Project Name: ALBUQUERQUE HISPANO CHAMBER OF COMMERCE

RE: Albuquerque Hispano Chamber of Commerce

TO: Sheran Matson, DRB Chair
FROM: Carmen Marrone, Senior Planner
RE: **Project #1004166, Hispano Chamber of Commerce**

On June 16, 2005, the EPC approved a Site Plan for Building Permit with Conditions involving the Hispano Chamber of Commerce, located on 4th Street SW. The DRB submittal generally meets the EPC conditions with the following exceptions:

**SHEET TITLE**  
PROPOSED NEW BUILDING EXTERIOR ELEVATIONS

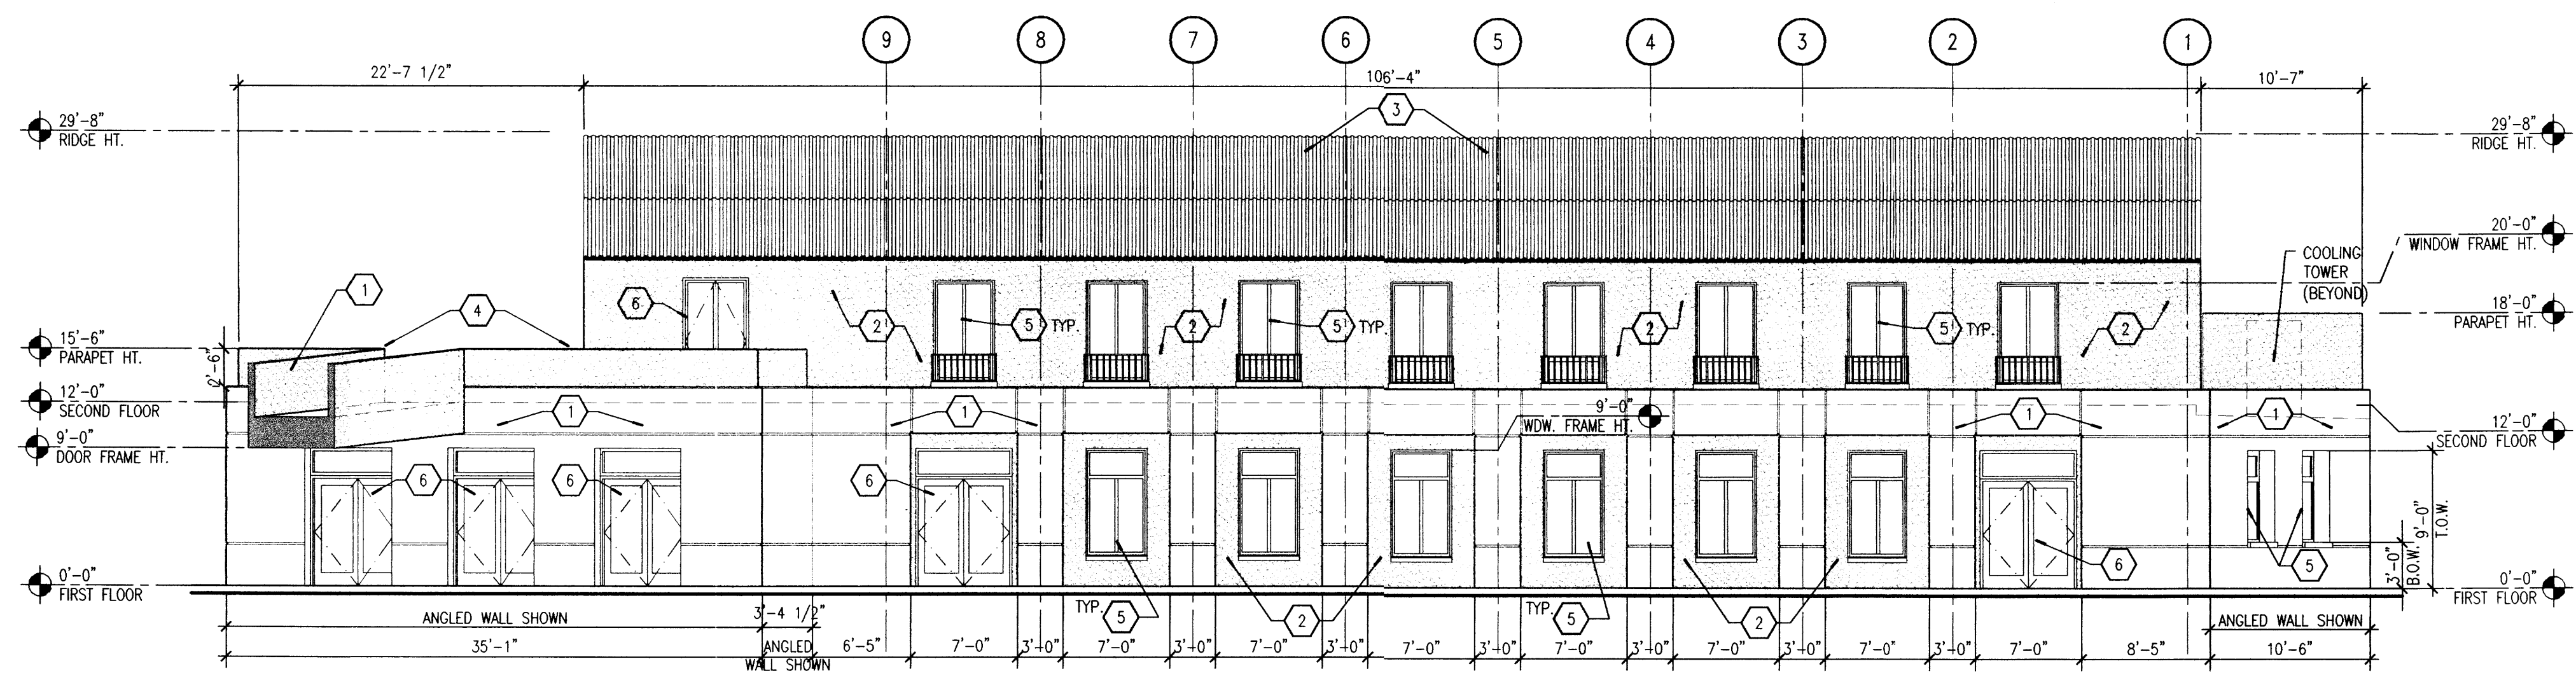
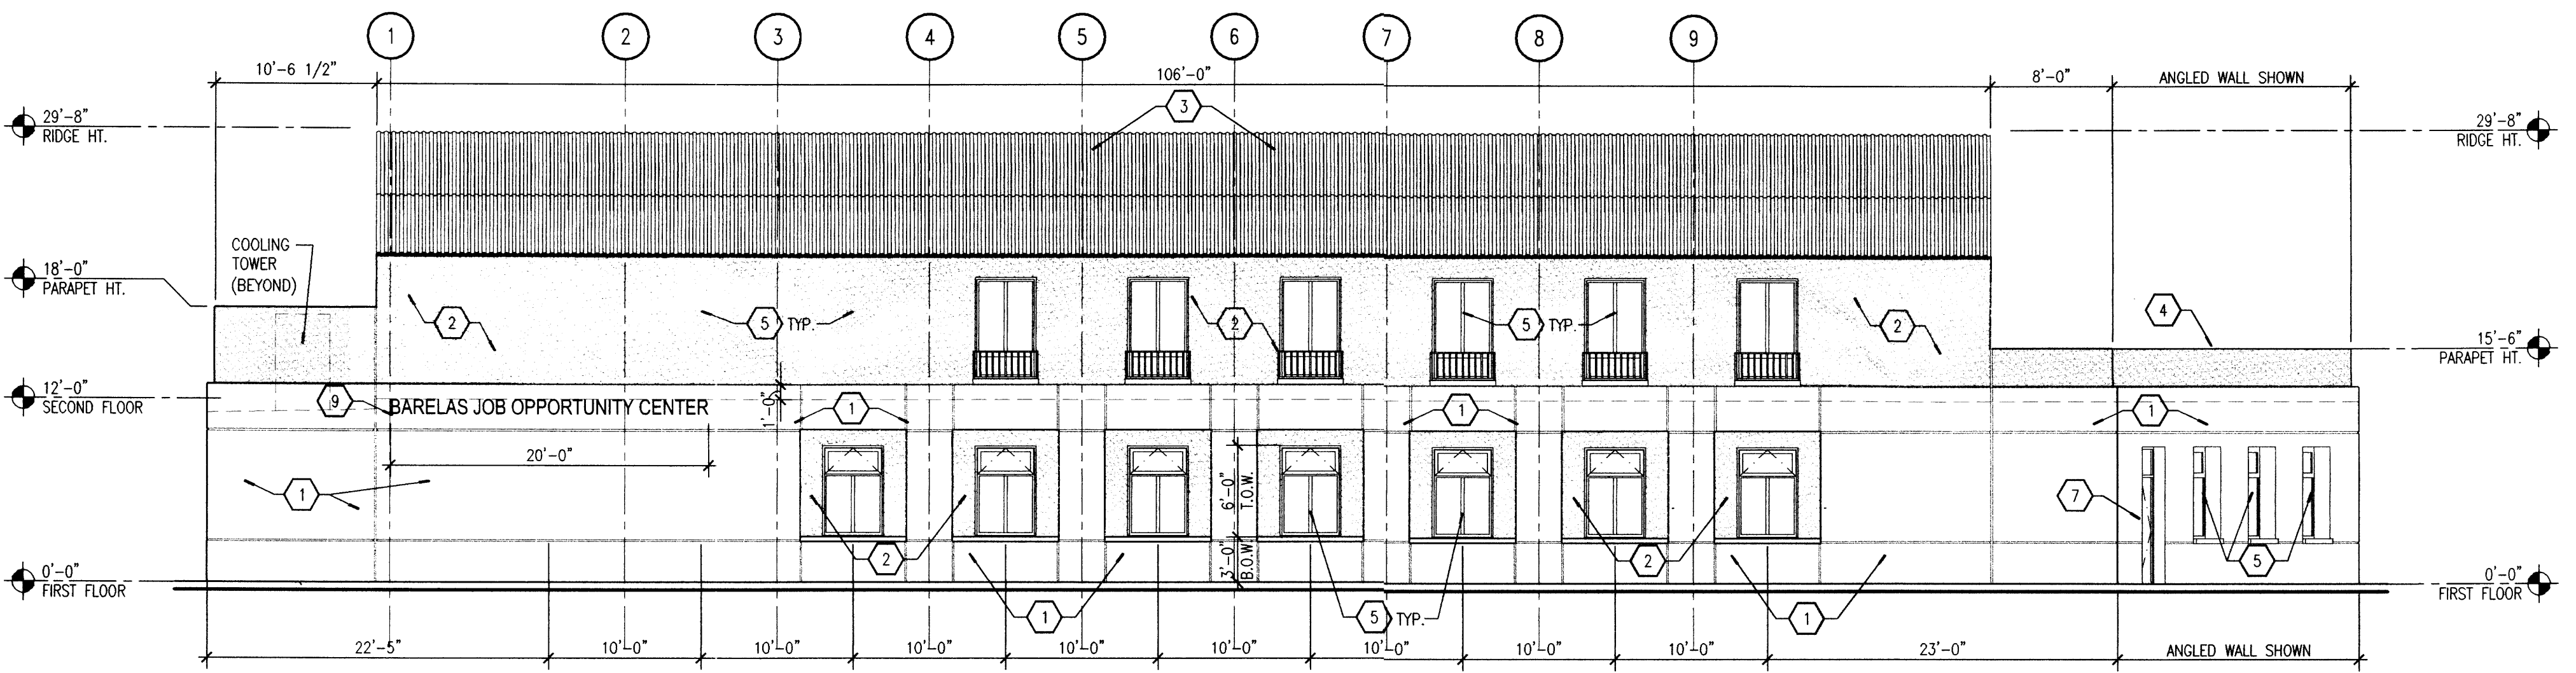
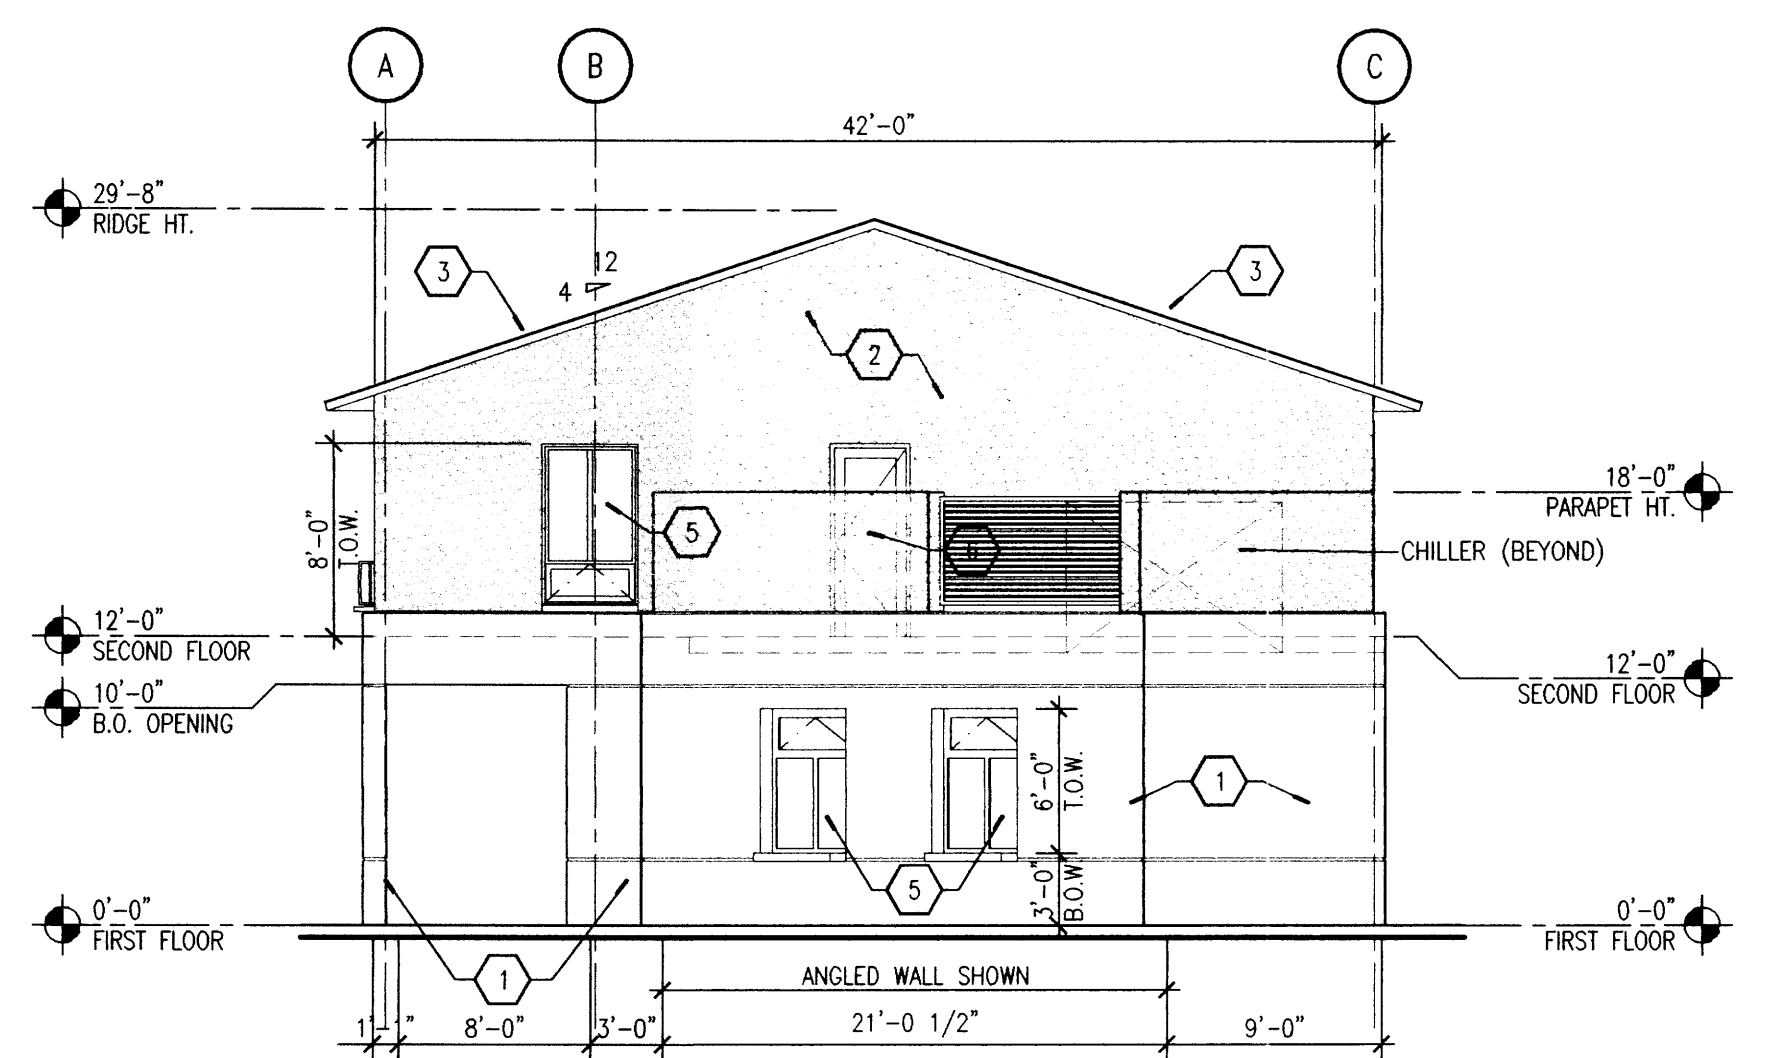
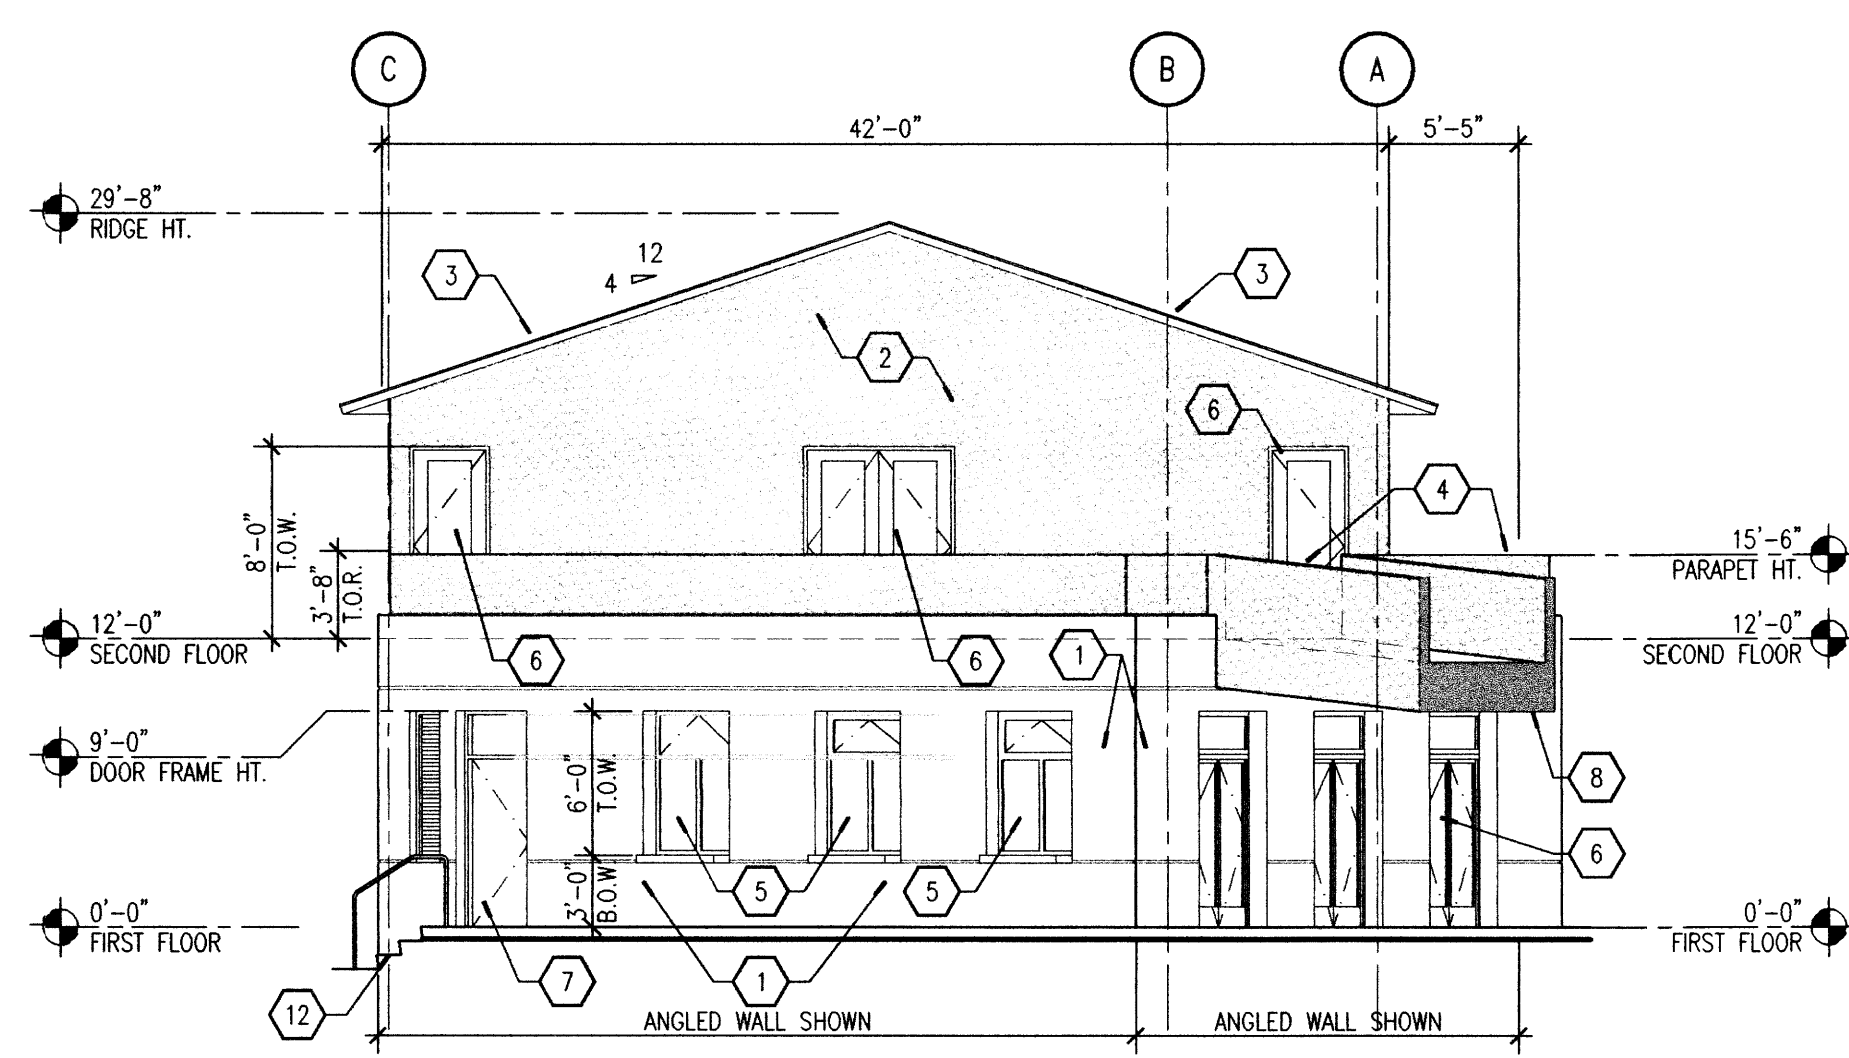
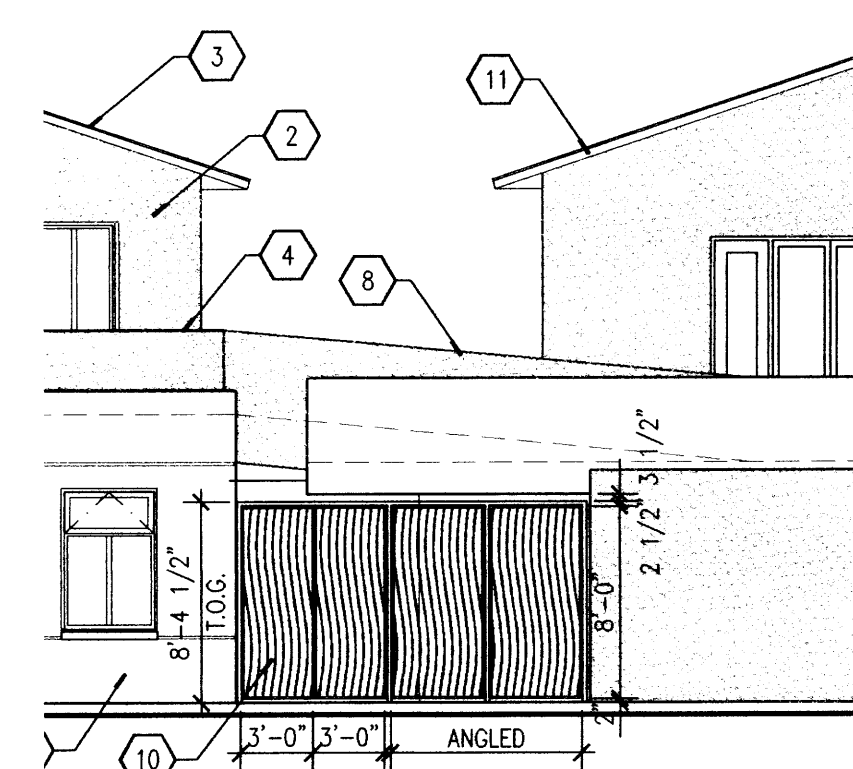
Condition 8: The building-mounted lights need to be shown on the west elevation of the building on Sheet A-201.
